WEST SUSSEX COUNTY COUNCIL CONSULTATION

TO:	Arun District Council FAO: Mr A Wood
FROM:	WSCC - Highways Authority
DATE:	25 June 2020
LOCATION:	Littlehampton Covered Market 26-28 Surrey Street Littlehampton BN17 5BG
SUBJECT:	LU/46/20/PL Demolition of existing building & construction of 1 No retail unit & 3 No. flats with associated external works & access. This application affects the setting of listed buildings & may affect the character & appearance of the River Road, Littlehampton Conservation Area. An amendment received.
DATE OF SITE VISIT:	n/a
RECOMMENDATION:	Advice
S106 CONTRIBUTION TOTAL:	n/a

SWEPT PATH ANALYSIS DIAGRAMS

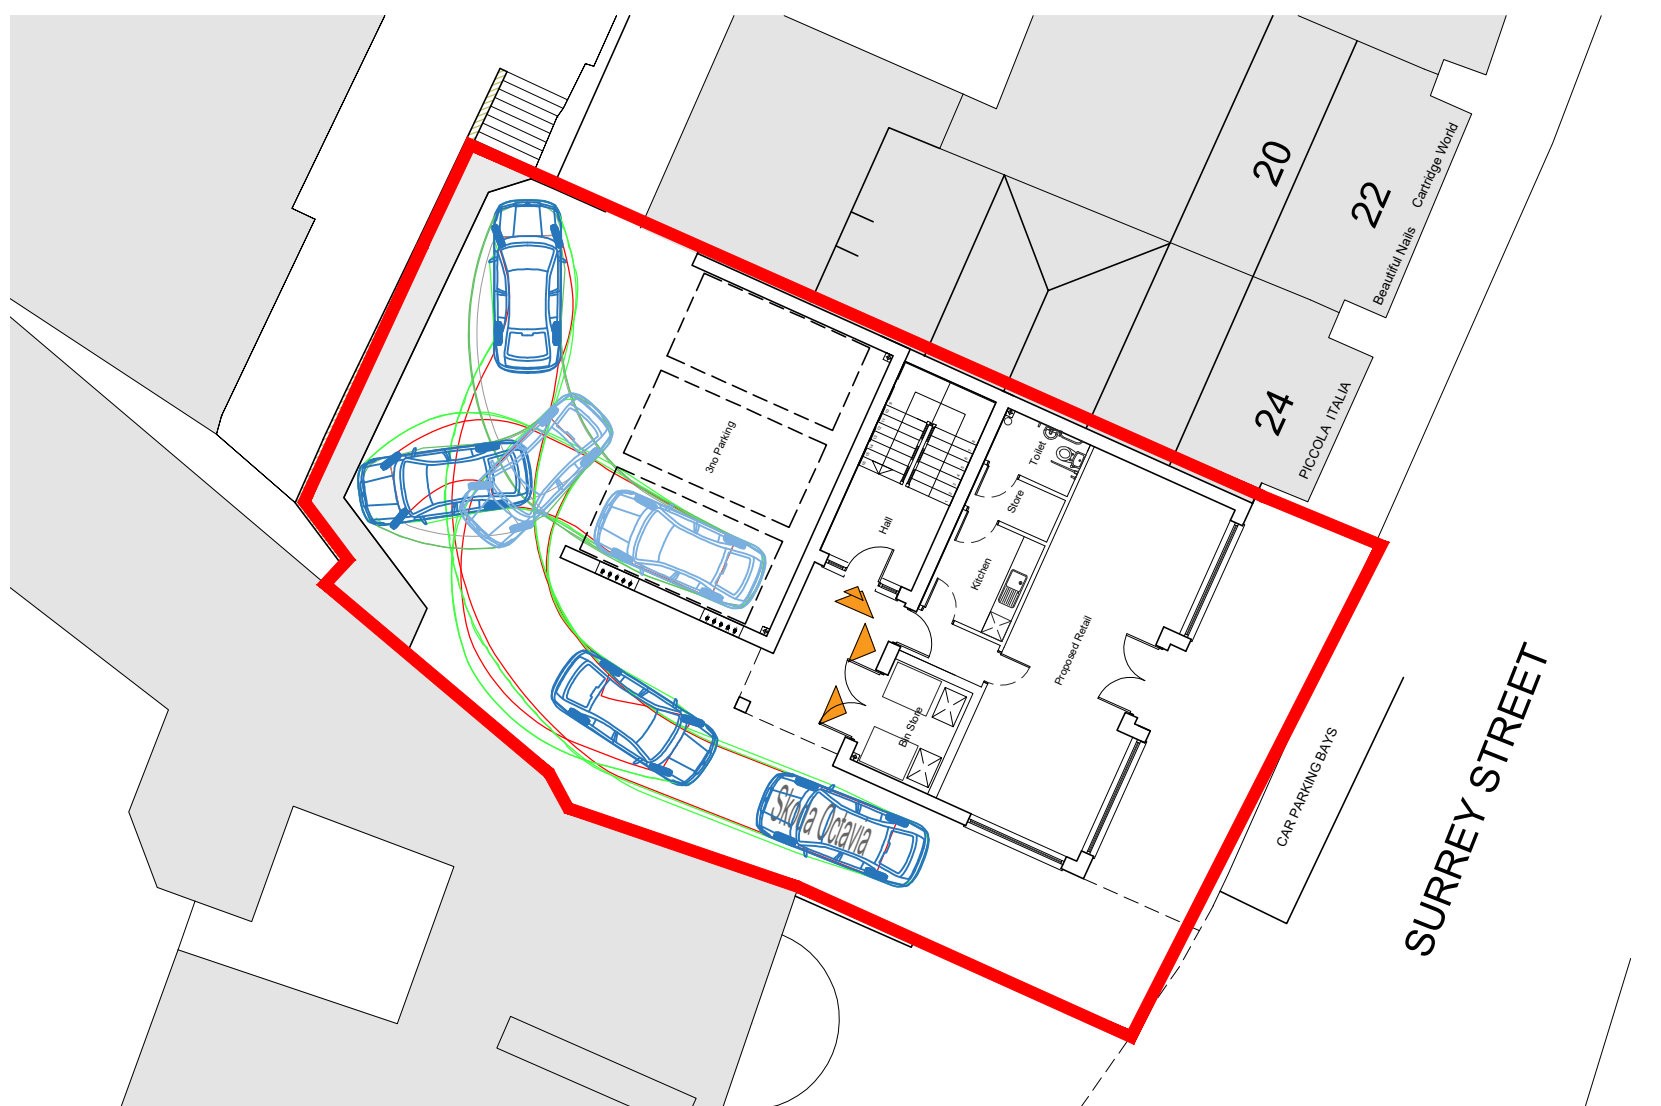
The parking layout has now been demonstrated on swept path tracking plan 085.0005.001 and Drawing 013 Rev P04.

Both plans demonstrate that the spaces are suitable sized. Accessibility has been demonstrated with swept path tracking which is acceptable.
